NSW RURAL FIRE SERVICE

Your reference: MP 10_0137 MOD 8
Our reference: D17/1731

Modification 8 to Huntlee New Town Stage 1

**Figure 4** – Proposed Asset Protection Zones (shown in red)

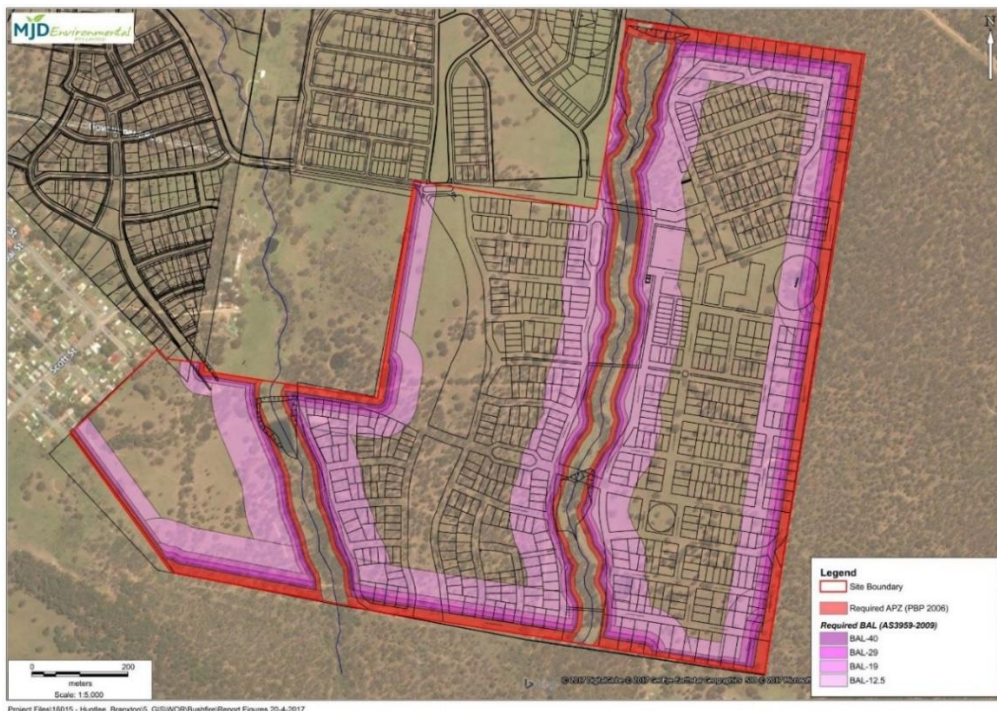
It is noted that perimeter roads previously proposed in the north-east corner of the proposal have been replaced by residential lots directly abutting the bush fire hazard. This is not the preferred arrangement as set out in *Planning for Bush Fire Protection 2006*. Further consideration should therefore be given at subdivision stage to the inclusion of perimeter roads in this area. Alternately the NSW RFS will require suitable enforceable instruments to be implemented at subdivision stage to prohibit future dwellings being constructed within the required asset protection zones in these areas.
